**Re: Cornell 12-Plex
200/202 Cornell SE
Request for Certificate of Occupancy
Transportation Development Final Inspection
Engineer's/Architect's Stamp dated 4-13-20 (K16D072A)
Certification dated 3-11-21**

Based upon the information provided in your submittal received 3-11-21, Transportation Development cannot approve the release of Certificate of Occupancy for the above referenced project.

SITE PLAN

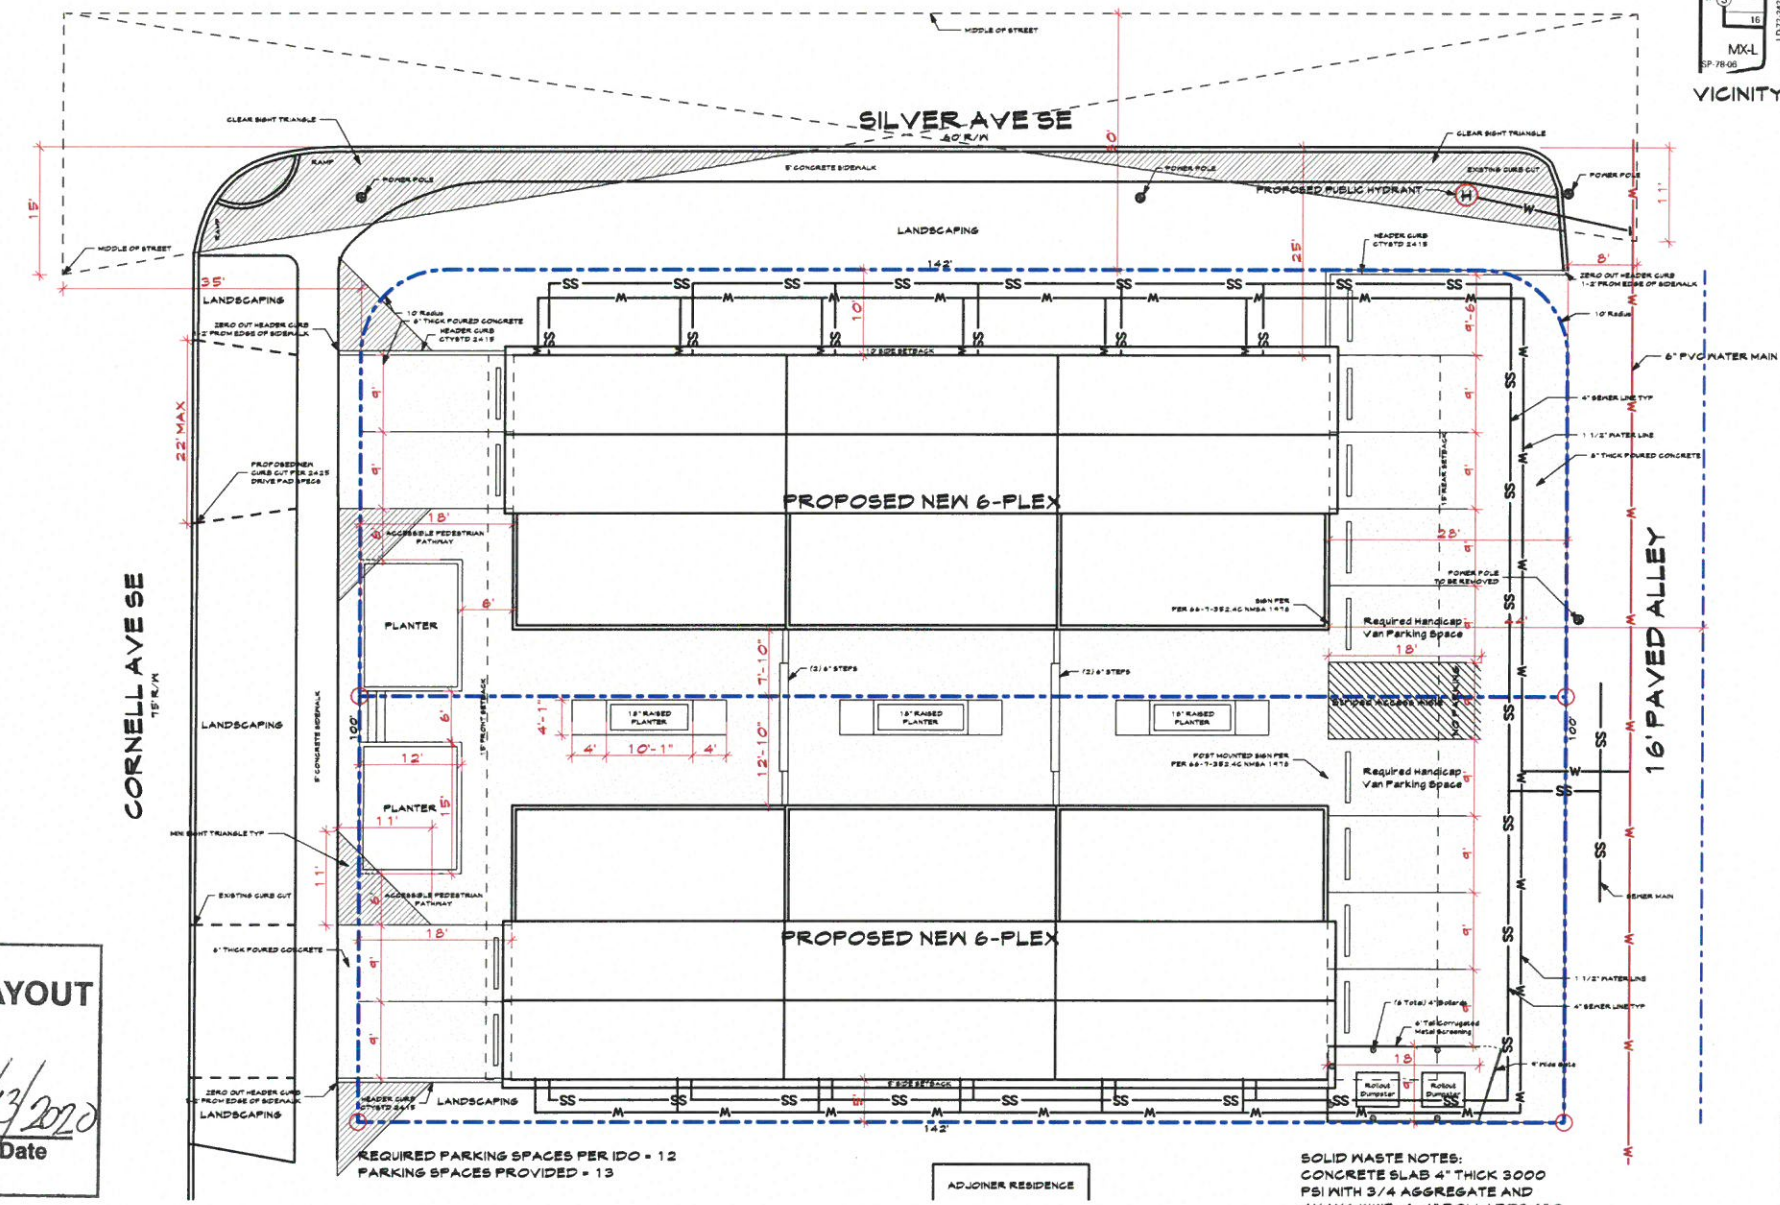
- The ADA accessible parking sign must have the required language per 66-7-352.4C NMSA 1978 **"Violators Are Subject to a Fine and/or Towing."** If that language is present it is not visible in the detail.
- Please add ADA International Symbol pavement markings to the ADA stalls.
- Provide conformation of accepted and approved work order.
- Remove construction equipment and debris on site.
